From: Jean Fraser
To: Will Savage
Date: 1/21/2016 4:18 PM
Subject: Prelim review comments 31 Fore St
Attachments: R6 Infill.doc

The following comments are from a preliminary review of the proposal at 31 Fore Street under the R-6 Infill Development Design Principles & Standards:

DRAWING NO.
C-10

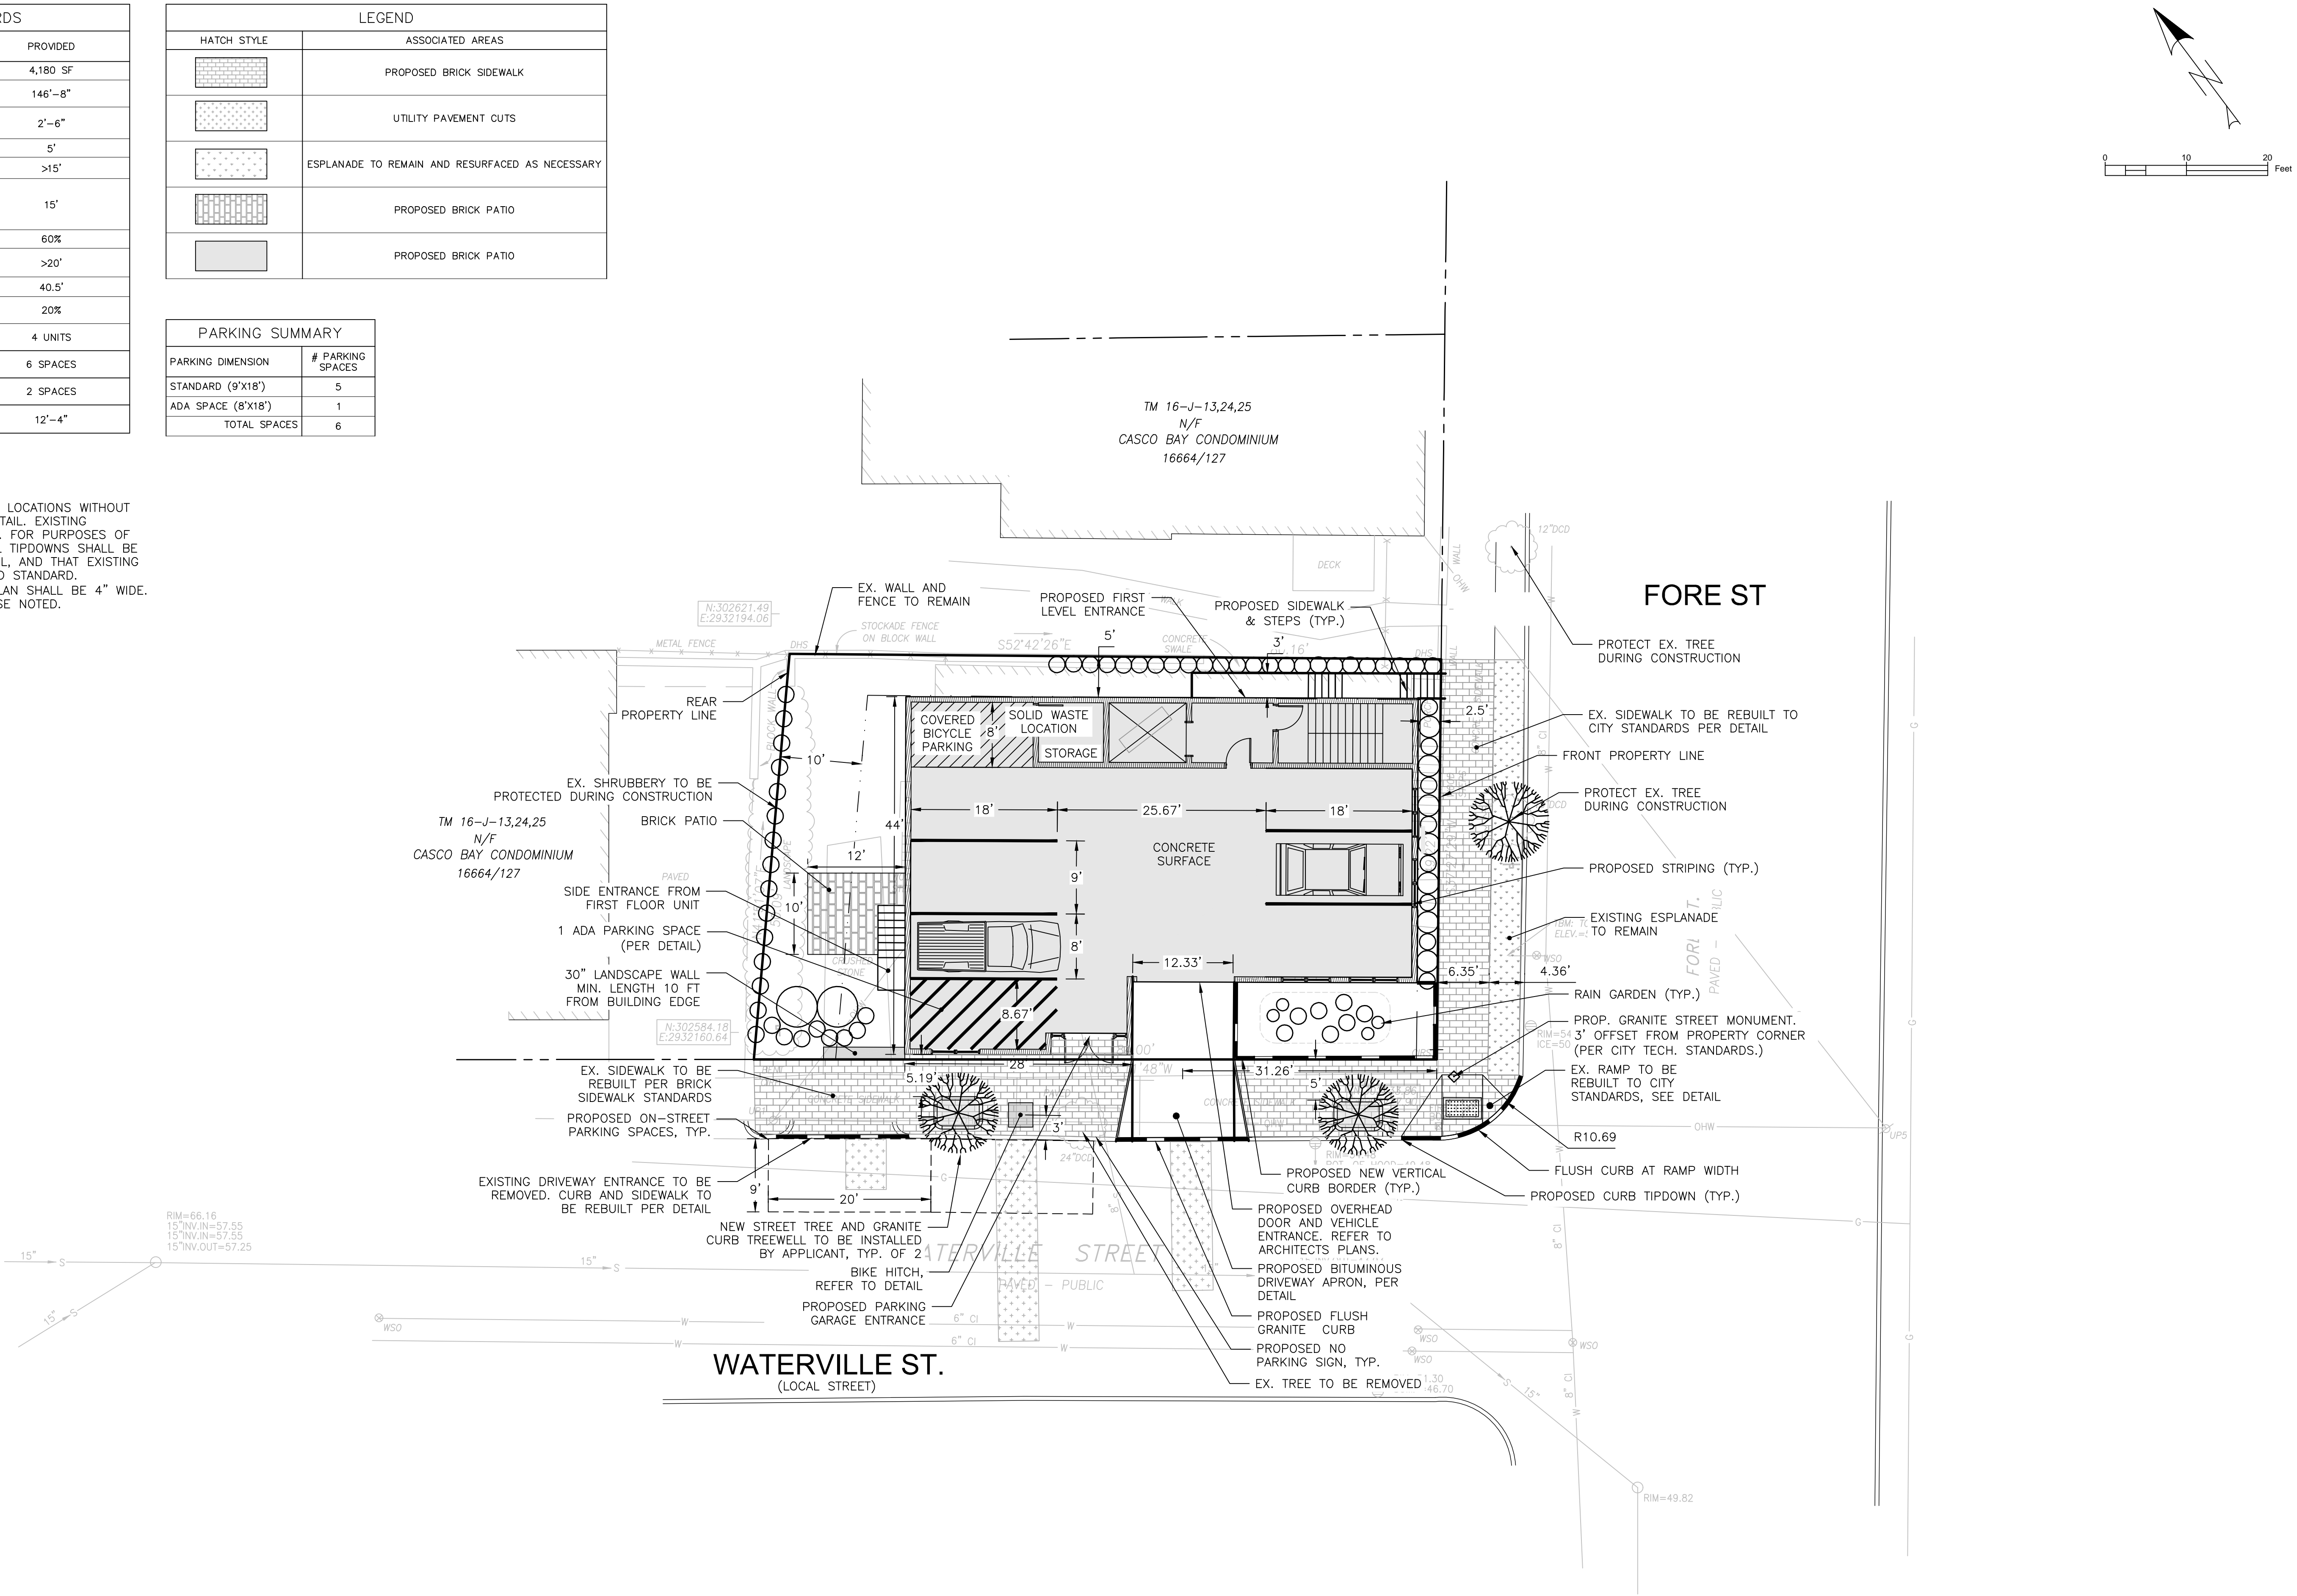
Structure Setbacks: *Portions of a structure above 35 ft shall be no closer than 10 ft from the side property line and no closer than 15 feet from the rear property line when such property line abuts a residential zone. Does not apply to side yards on side streets.* (show setback lines and show that building above 35 ft in height meets these setbacks- appears not to on the uphill side and maybe also at the rear. The standard relates to the scale and bulk of the building, so it would not matter what's inside that part of the building. All parts of the building need to meet these applicable setback line(s), which should be shown on the plan. Since there is another abutting building very near we would expect the setbacks to be met.)

Show distance from access drive to corner (Fore/Waterville) and request waiver for this as it does not appear to meet Technical standards (section 1.7.1.7). (Reviewer is likely to grant the waiver)
